Application for a non-material amendment following a grant of planning permission.

2 NO SEMI-DETACHED HOUSES

Reference number:LU/291/15/PL

CHANGE TO EAST AND WEST FIRST FLOOR WINDOWS

tp727/13a

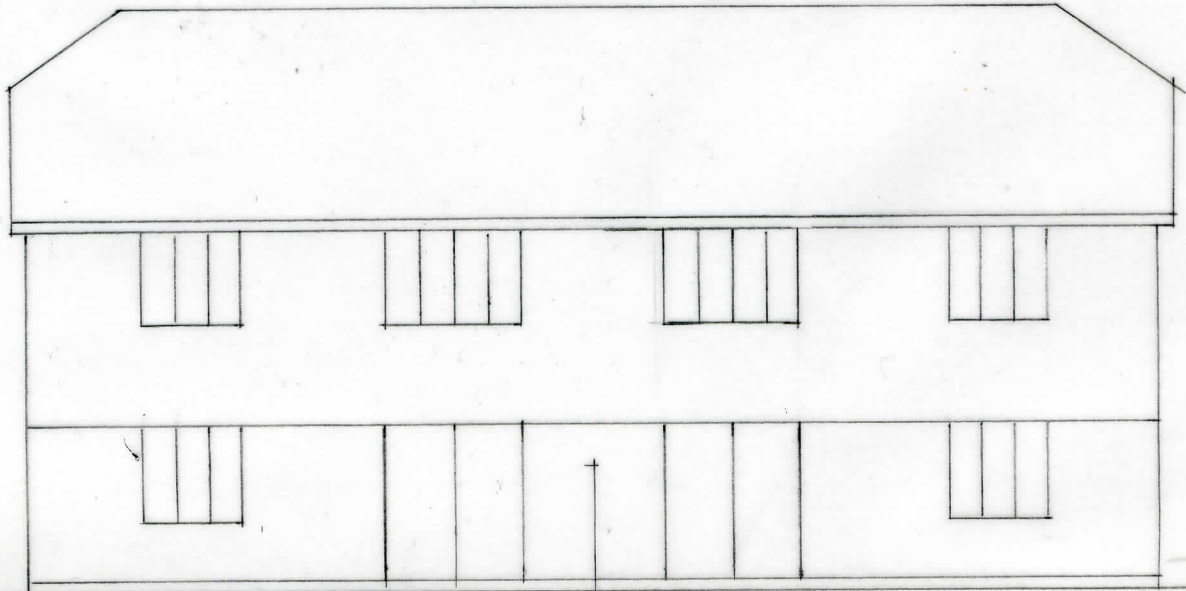
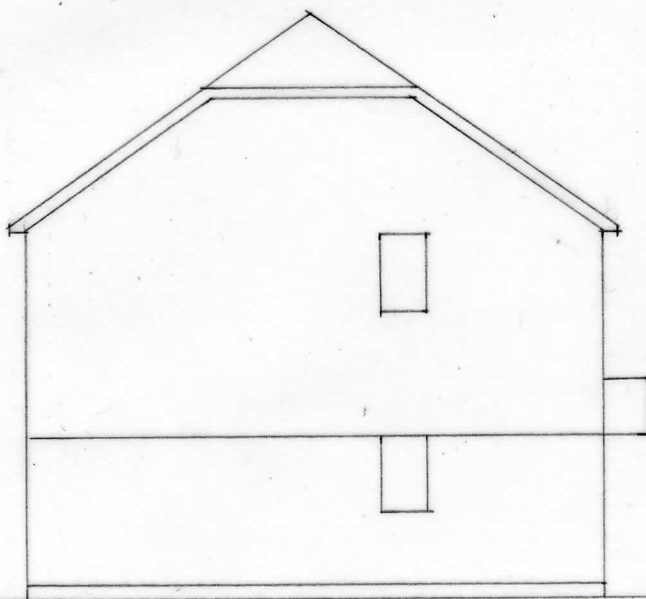
REDUCED SIZE OF PATIO DOORS

REPLACE BOARDING WITH WHITE RENDER

Render in keeping with other houses

reduced window sizes simplified construction and reduced heat loss
